RE: Whitaker Boundary Line Adjustment (BL-15-00017)

Community Development Services is in receipt of the above referenced application. The application has been deemed complete and **preliminary approval** is hereby granted. Pursuant to Kittitas County Subdivision Code Chapter 16, please note the following items must be completed prior to final approval of the administrative segregation and must be submitted to our offices for review:

TO: Kaycee Hathaway, Community Development Services
FROM: Kelly Bacon, Engineer Technician I *KB*
DATE: January 15, 2016
SUBJECT: Whitaker BL-15-00017

RE: BL-15-000017 Whitaker

CRUSE & ASSOCIATES
PROFESSIONAL LAND SURVEYORS
217 East Fourth Street P.O. Box 959
Ellensburg, WA 98926 (509) 962-8242
WHITAKER PROPERTY

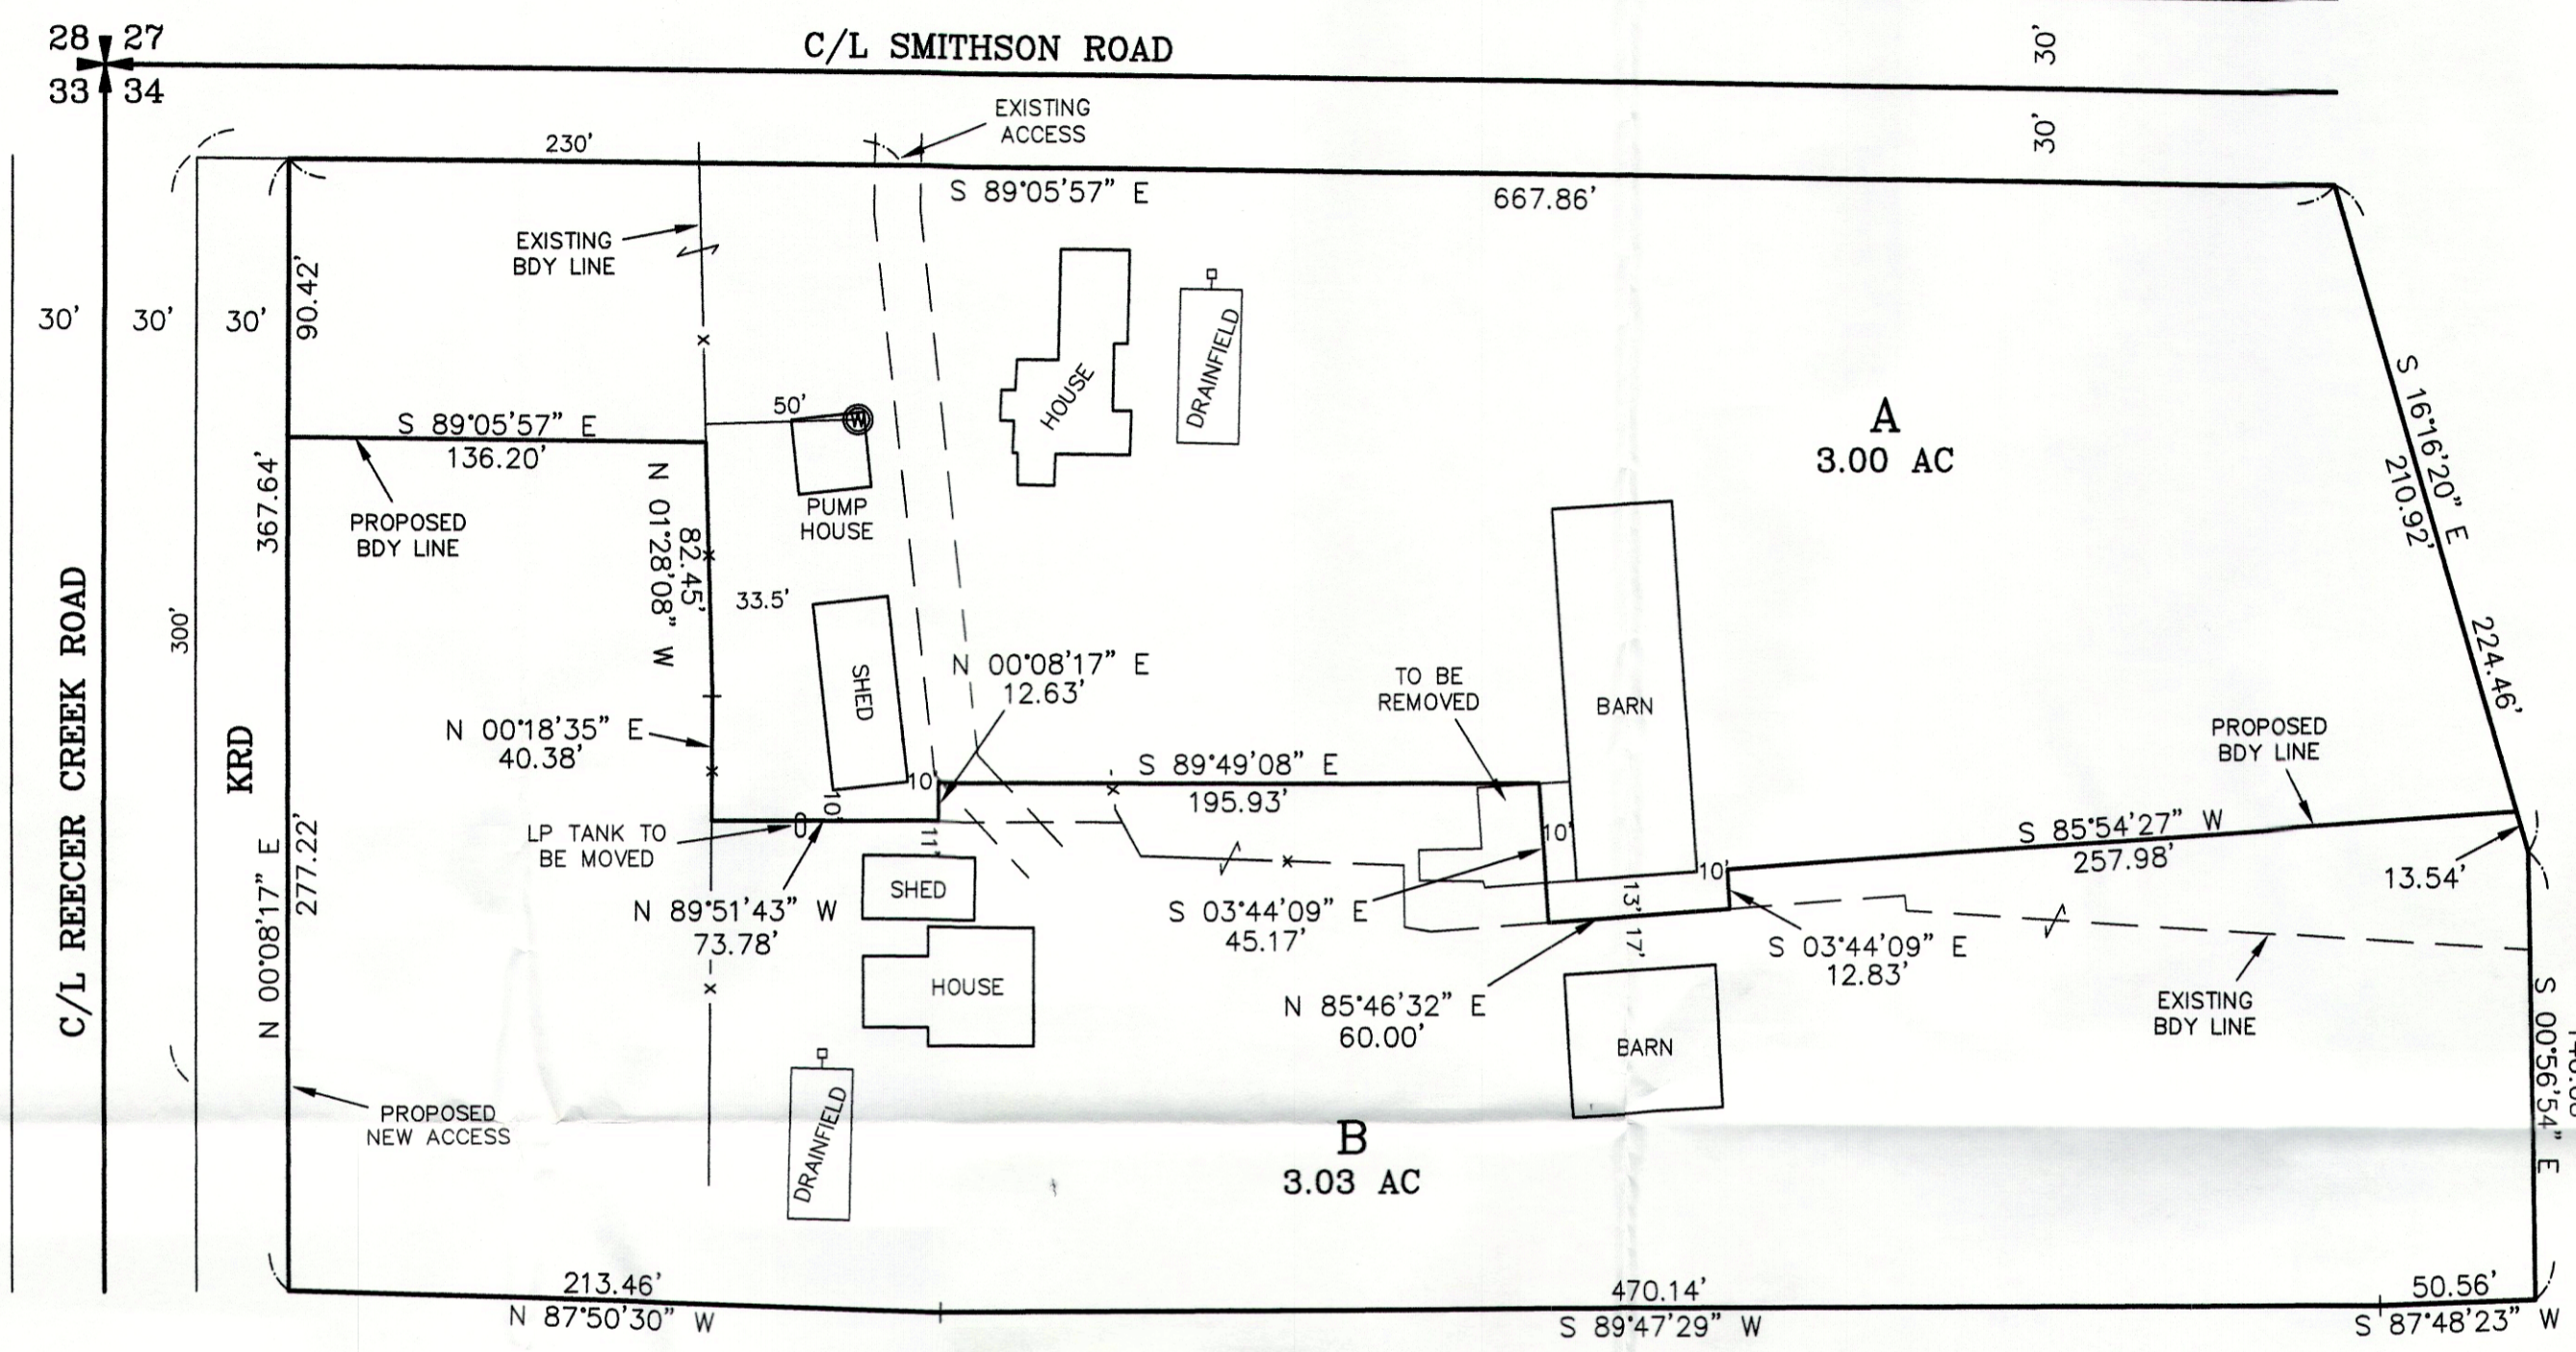
1. Prior to final approval of this application, Public Health requires a site plan be submitted showing the location and setback measurements of the well on the south parcel. (See comment letter)
2. Prior to final approval of this application, Public Works requires a revised legal description that describes the final configuration of the subject property. (See comment letter)
3. A recorded survey displaying legal descriptions and the new acreage and lot dimensions of each parcel must be submitted to our office prior to final approval.
4. Full year's taxes need to be paid for all tax parcel numbers per requirement of the Kittitas County Treasurer's Office. **Please contact this office when this is accomplished as the Treasurer's office will not be aware of your pending application.** No paper work or receipt is required just a phone call or an email will suffice.

After reviewing this application the setback measurements for the well on the north parcel are evident but the location of the well on the south parcel is not marked on the maps. In order for final approval of this application, Public Health requires a site plan be submitted showing the location and setback measurements of the well on the south parcel.
